CITY OF ALBUQUERQUE

January 27, 2011

Re: Coronado Center East Entrance Renovation, Grading Plan
Engineer's Stamp dated 12-9-10 (H-18/D005B)

SITE
GRADING
PLAN

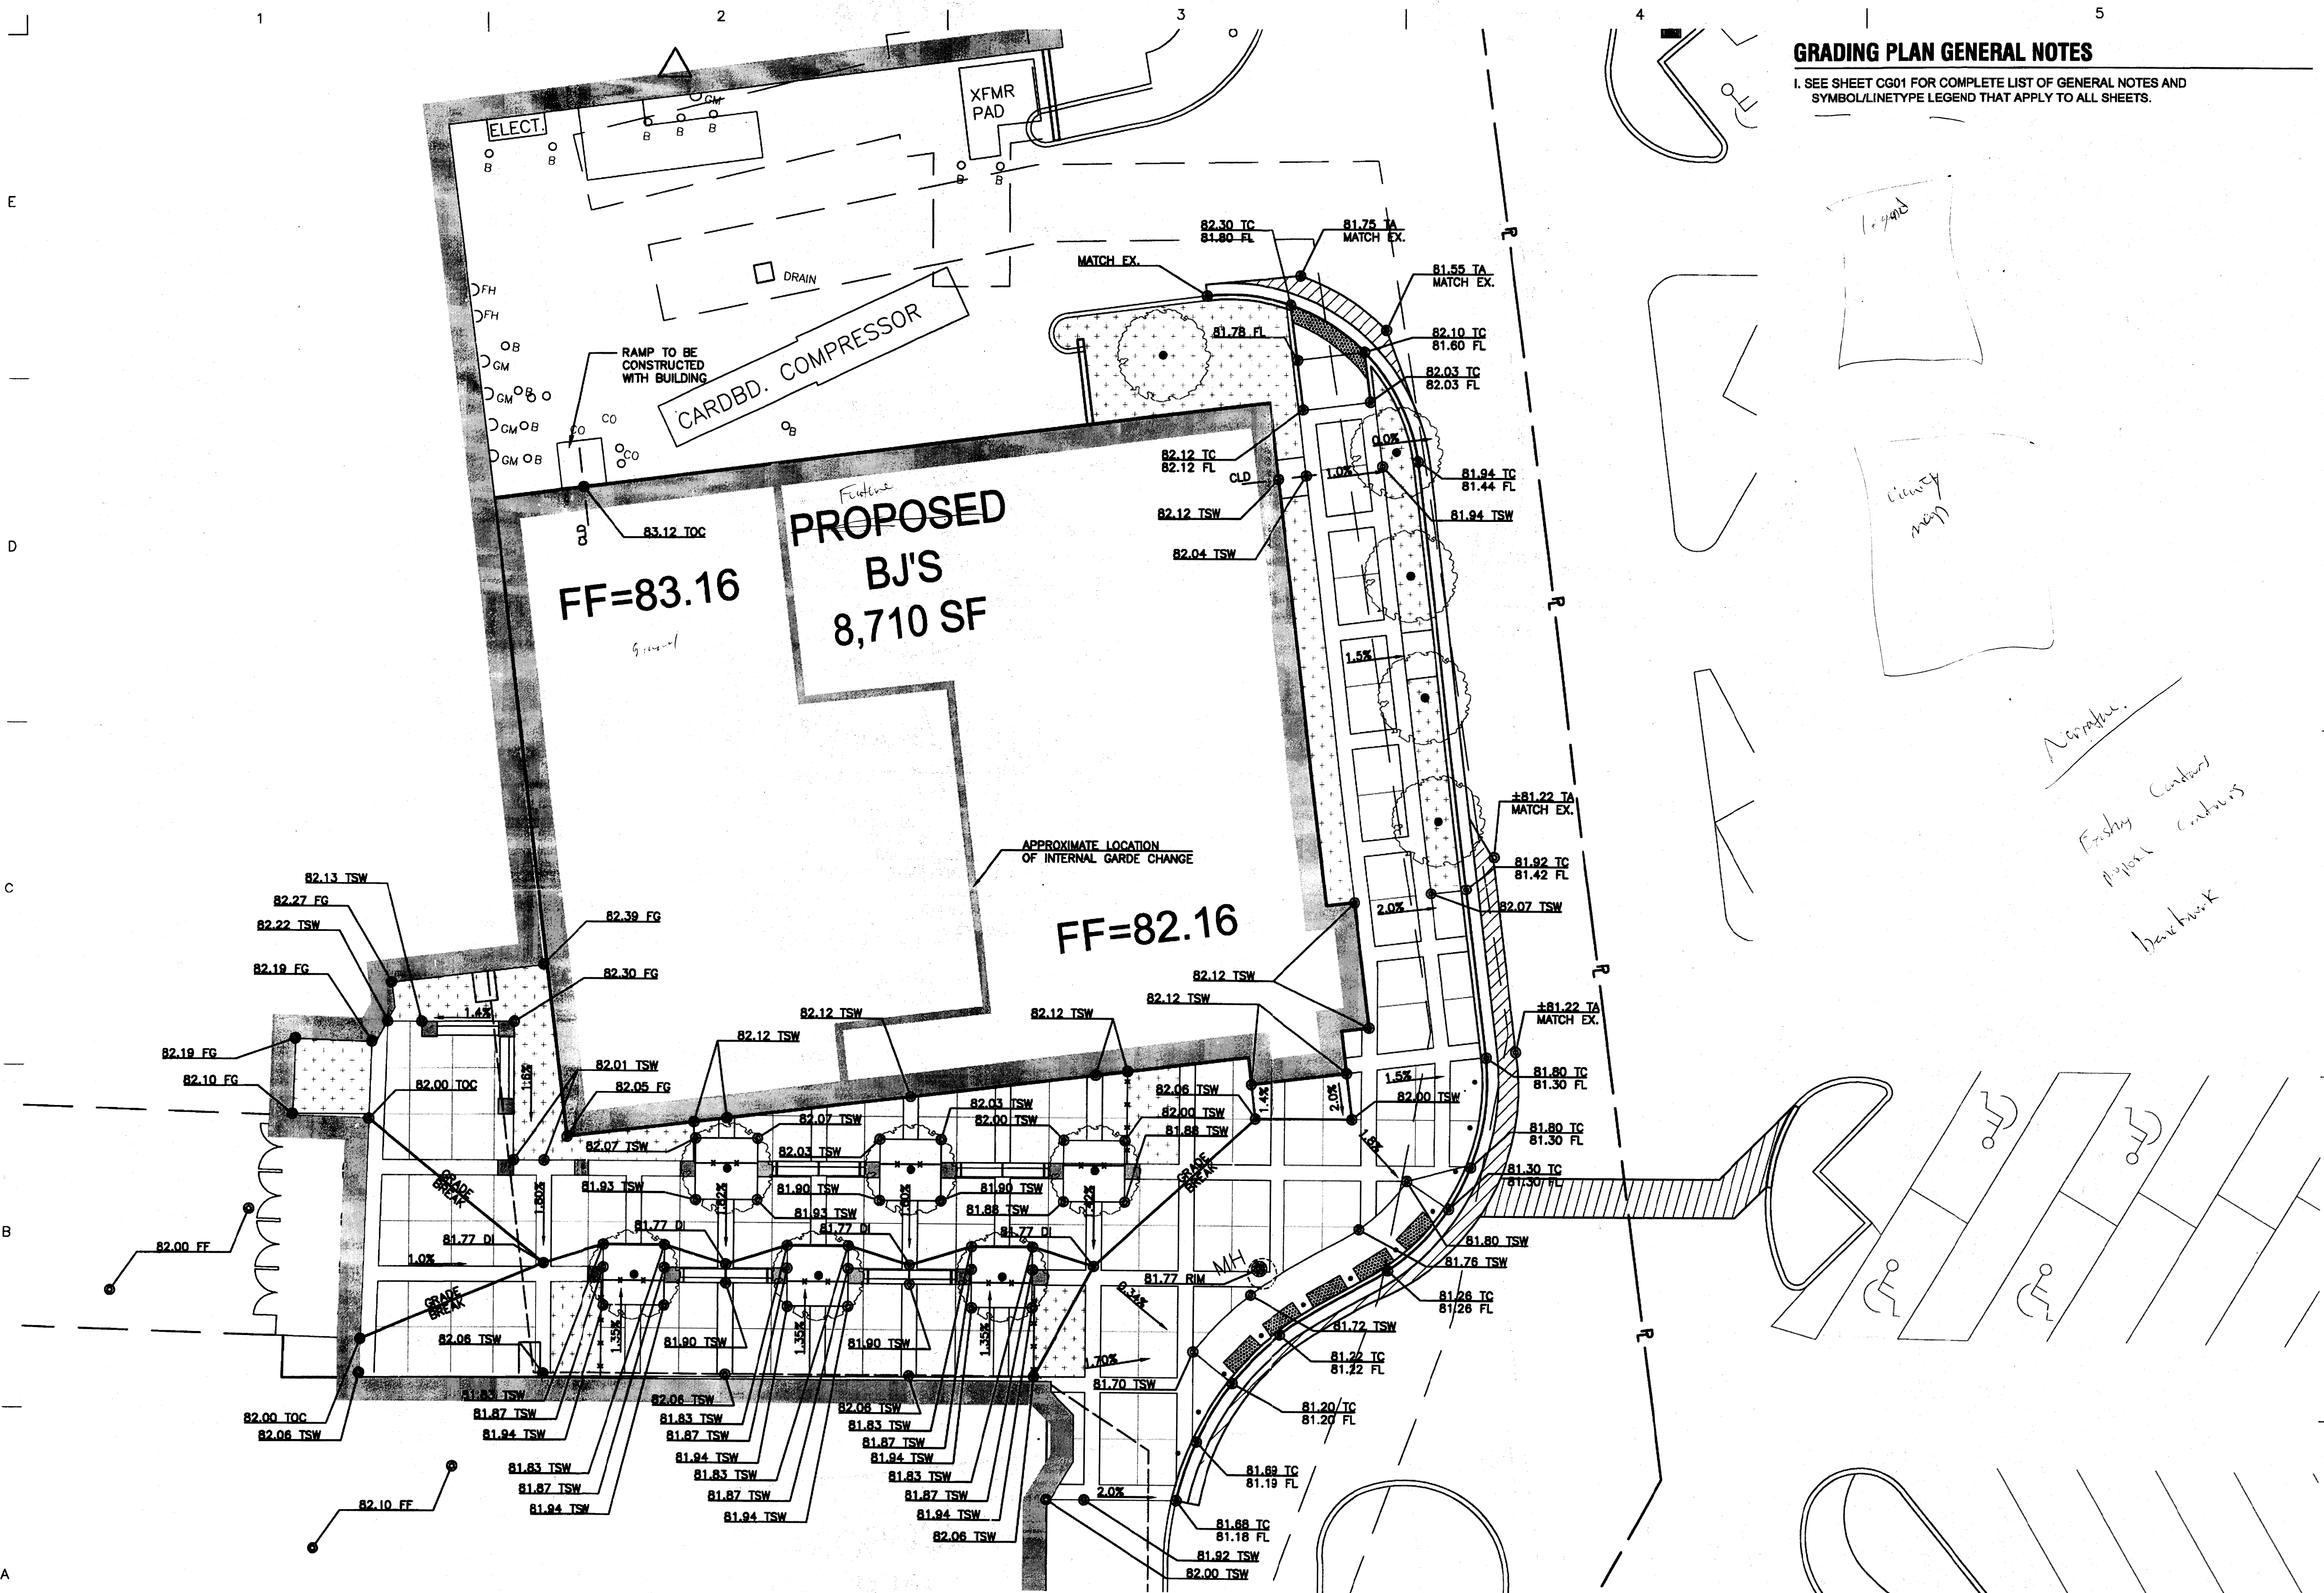
- Provide drainage calculations for the scope of work.
- Provide a drainage narrative of the scope of work comparing existing and proposed conditions. This may be done directly on the grading plan or on a separate sheet, in which it would require a signed engineer's stamp.
- Provide a vicinity map, legend, benchmark information (Albuquerque control survey vertical datum), and legal description of the site.
- Provide proposed improvements superimposed onto existing conditions, including contours and spot elevations.
- It is suggested that a different symbol be used to signify the drop inlets other than the symbol for spot elevations.
- It appears that the proposed BJ's is an existing building. Therefore, just show the finished floor elevations as an existing condition.
